# East Anglia TWO Offshore Windfarm

## Appendix 26.1 Traffic and Transport Consultation Responses

### Environmental Statement Volume 3

Author: Royal HaskoningDHV  
Date: October 2019  
Revision: Version 1

ACCESS 1  
SIZEWELL GAP

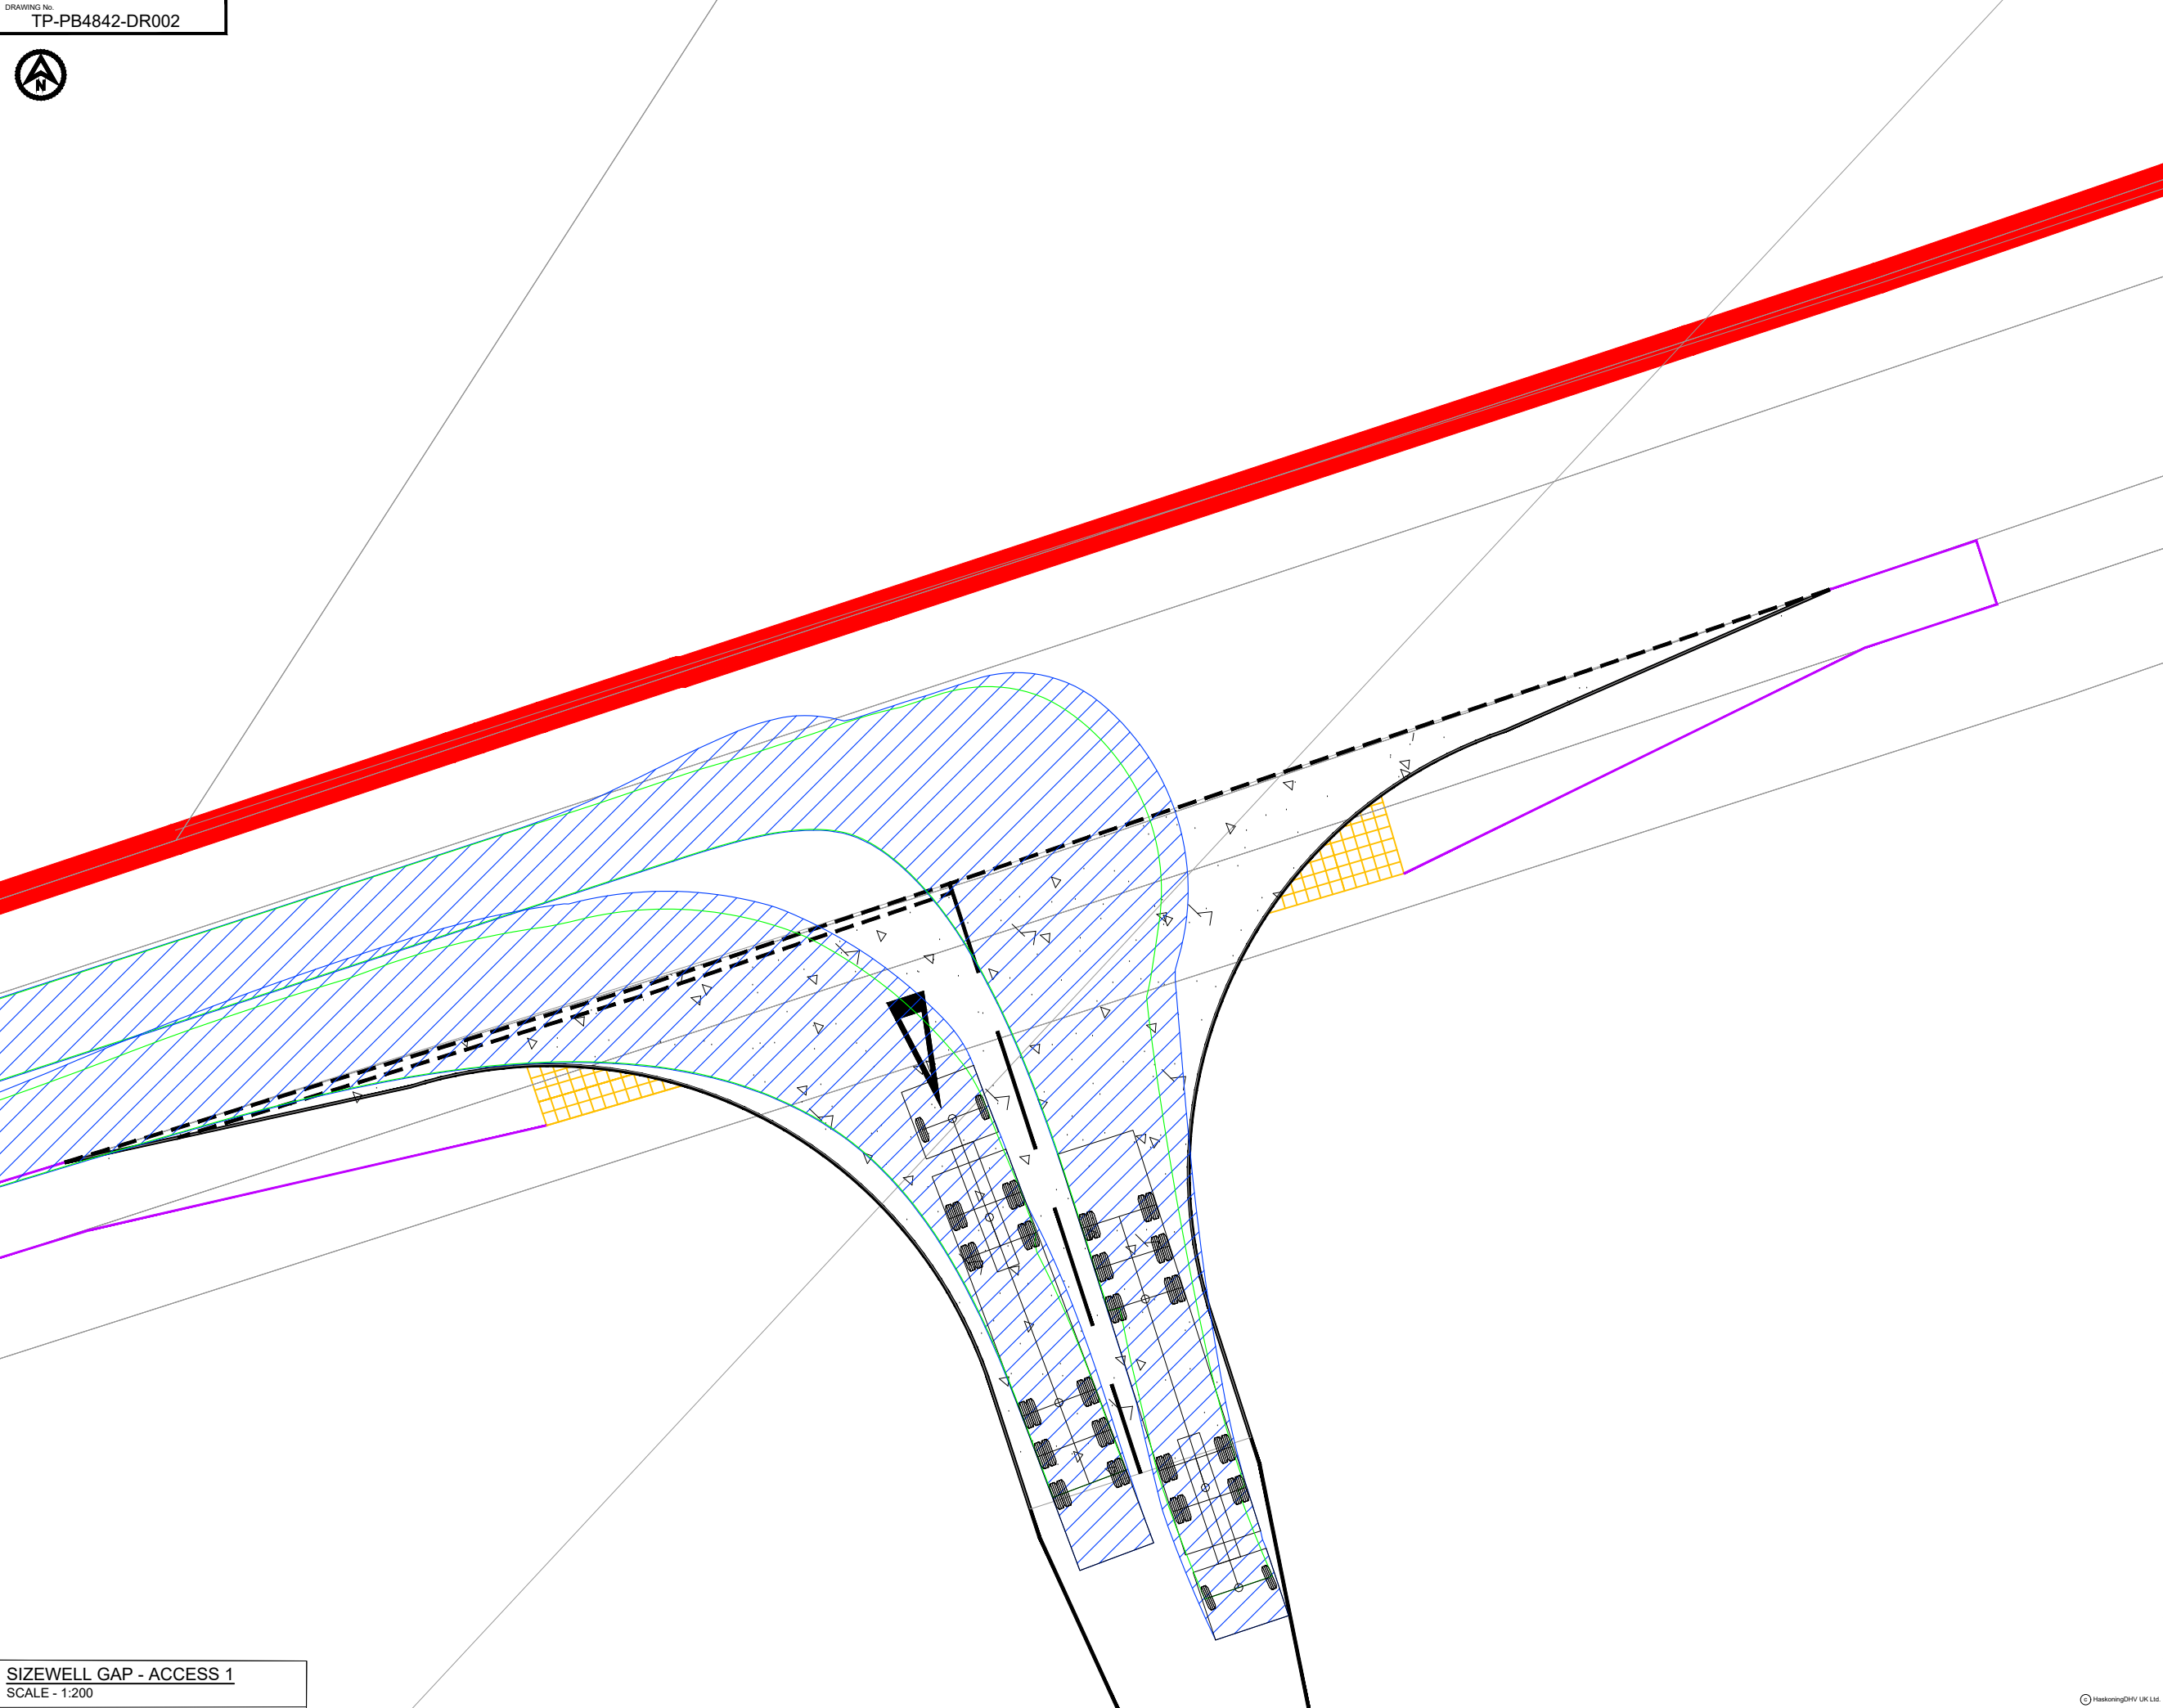
Leiston-cum-Sizewell Town Council	21/12/2017 Scoping Response	The access to any potential site and how the access road will be fenced off should be addressed and a very	Preliminary access concepts are provided within <b>Appendix 26.18</b> .

SIZEWELL GAP - ACCESS 2  
SCALE - 1:200

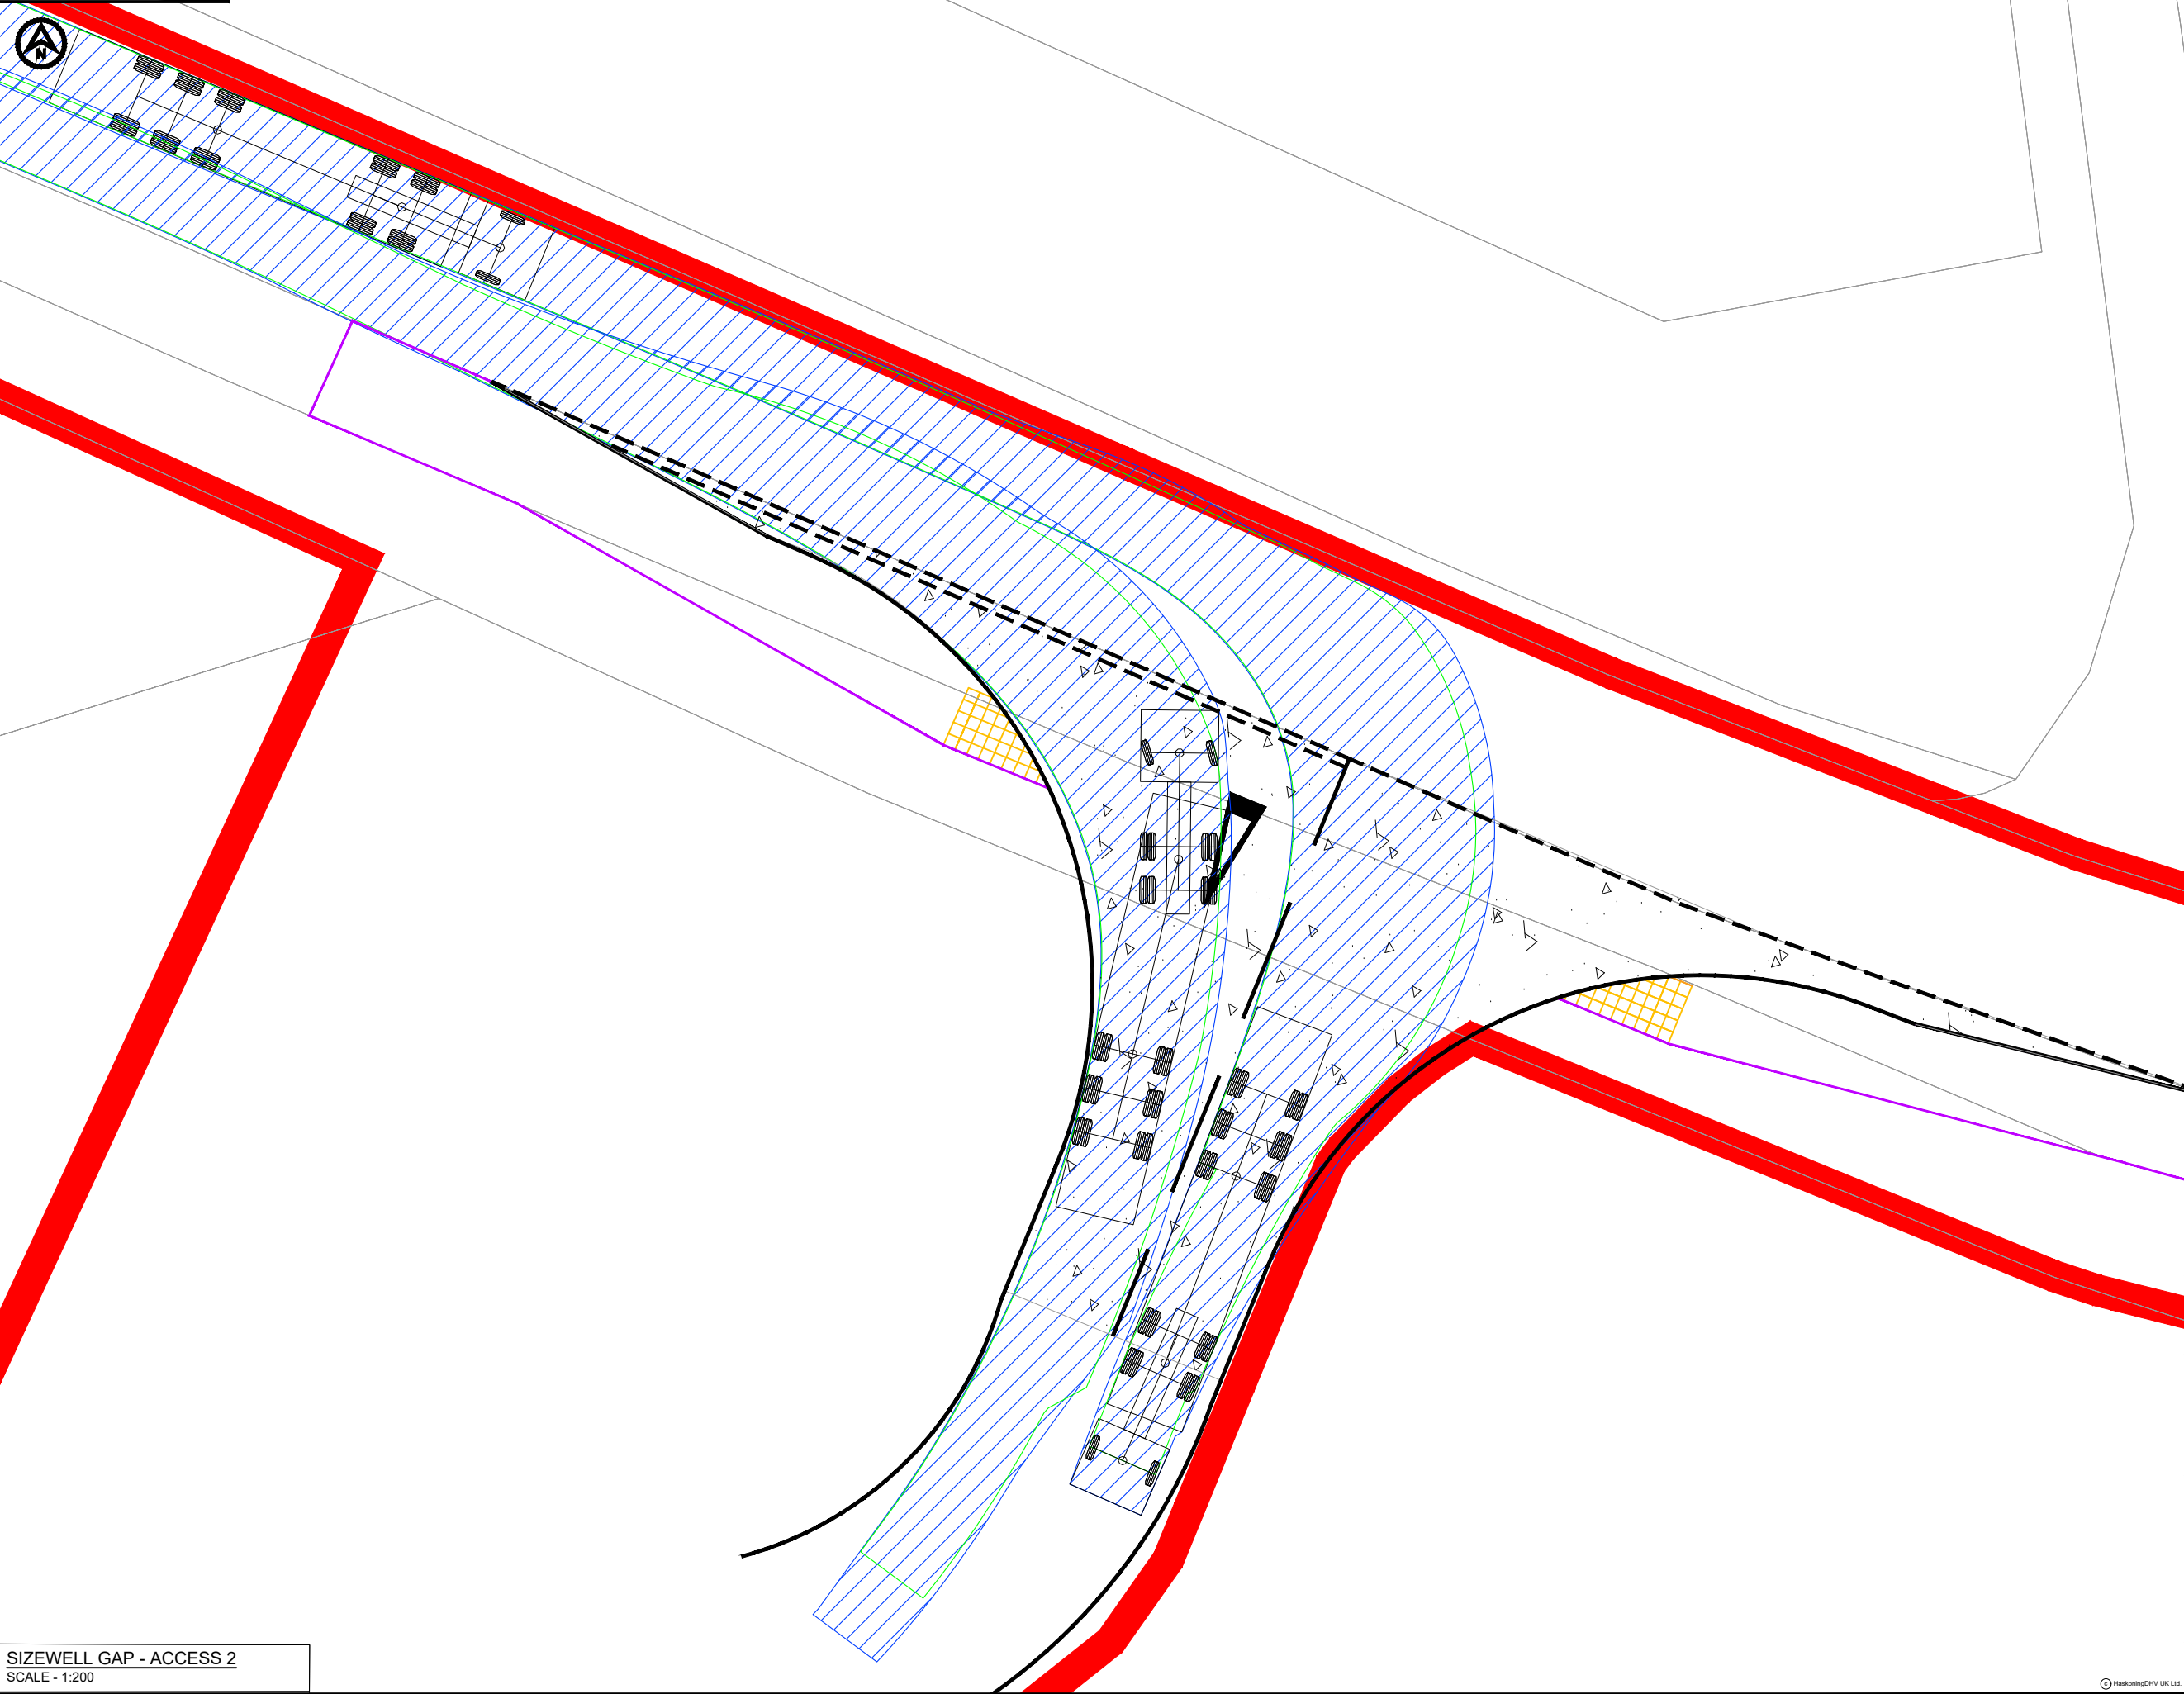
Suffolk County Council and Suffolk Coastal District Council	27.03.2019 Section 42 Consultation Response	For Access 2 off Sizewell Gap Road, due consideration should be given towards the proposals for a cycleway associated with Sizewell C at this location and how the proposed footway could tie-in with this facility.	
Suffolk County Council and Suffolk Coastal District Council	27.03.2019 Section 42 Consultation Response	The PEIR indicates that an outline Construction Traffic Management Plan (CTMP) would be submitted as part of the DCOs and would include details of the measures to be adopted to ensure that traffic demand forecasts are not exceeded, mitigation measures and Travel Plan measures, and the Councils would expect greater clarity on how the proposals will support sustainable transport including through protection of and improvements to the Public Rights of Way network.	An OTP is provided with the DCO submission, secured under the requirements of the draft DCO. The OTP provides details of proposed measures to support sustainable travel.
